From: Sue Howell <Sue.Howell@arun.gov.uk>
Sent: 25 June 2020 15:09
To: Planning.Responses <Planning.Responses@arun.gov.uk>
Cc: Simon Davis <Simon.Davis@arun.gov.uk>
Subject: RE: Planning Consultation on: BN/50/20/PL

Response to Planning Application

Application ref: BN/50/20/PL

Description: Demolition of existing structures onsite & erection of 42 No. dwellings with access, parking, landscaping & associated works. This application is a Departure from the Development Plan.

Landscape Led Design

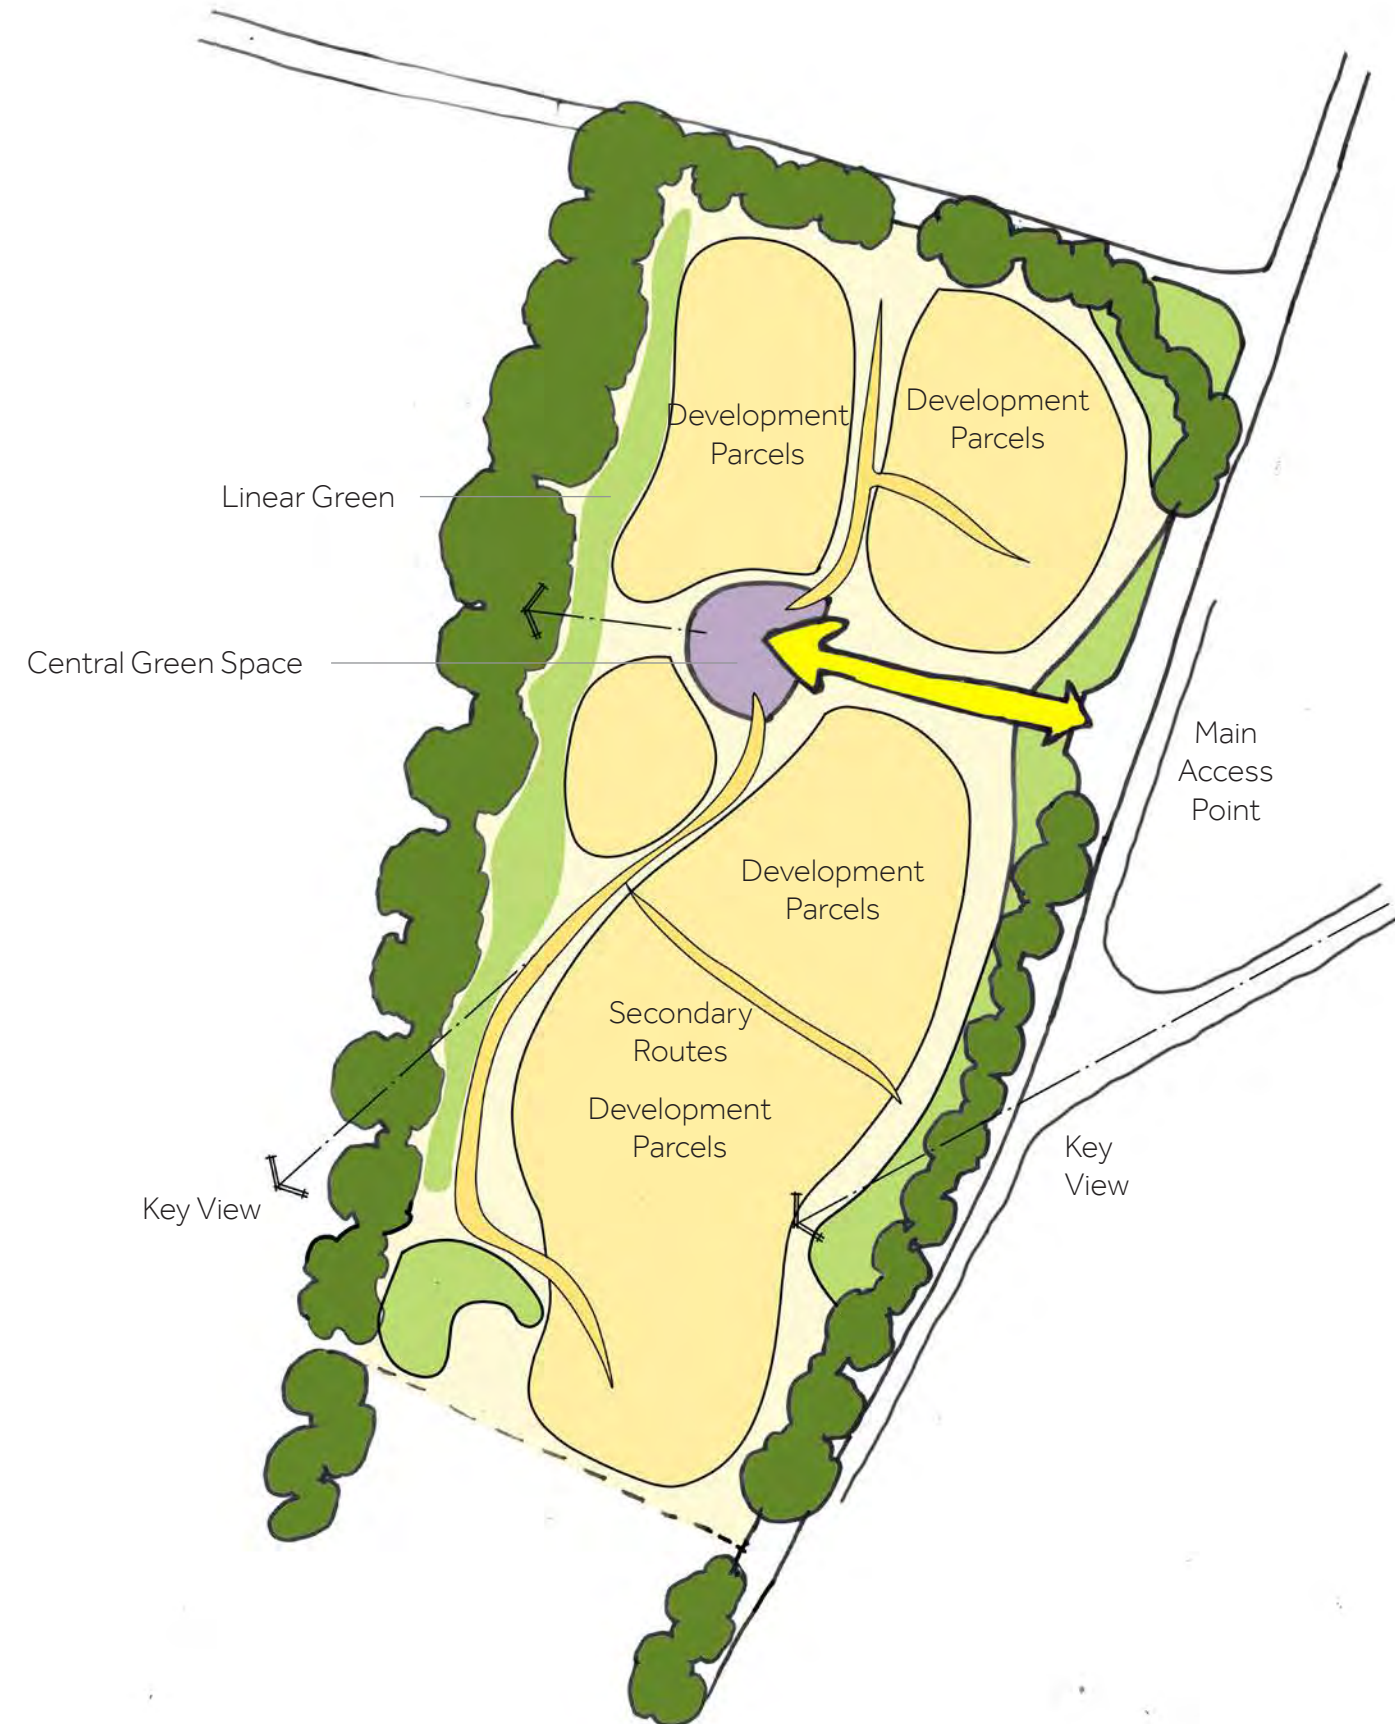
The indicative layout has shown 42 dwellings within the proposals with areas of POS, located mainly to the periphery of the development, largely to accommodate existing trees. These open space area must be usable open space not just left over parcels of land, consideration should be given to facing dwellings onto POS areas in line with good design principles and consideration of a more central area of POS could be explored.

A development of this size will require the provision of onsite POS minimum area of 2,956m² plus the provision of onsite, unequipped natural play LAP to include such features as landform, boulders or logs, seat and litter bin and onsite equipped LEAP 508m². Confirmation of the area of POS being proposed would be required. There does not appear to be any provision for children's play indicated on the indicative drawings.

There does not appear to be any SuDS features indicated, should the need for SuDS be required with the development then these areas should not be included in the total area of usable POS calculations. Further detail would also be required regarding depths and indication of timeframe for water holding periods ie dry feature or water holding body. This would be particularly relevant because of the proximity in relation to play and dwelling boundaries.

Pedestrian and cycle routes within the development should be a considered design feature and their meaningful connection to beyond the site detailed. The pathways shown in the Colour Landscape Masterplan April 2020 would appear to not have any meaningful connection either within the site or beyond.
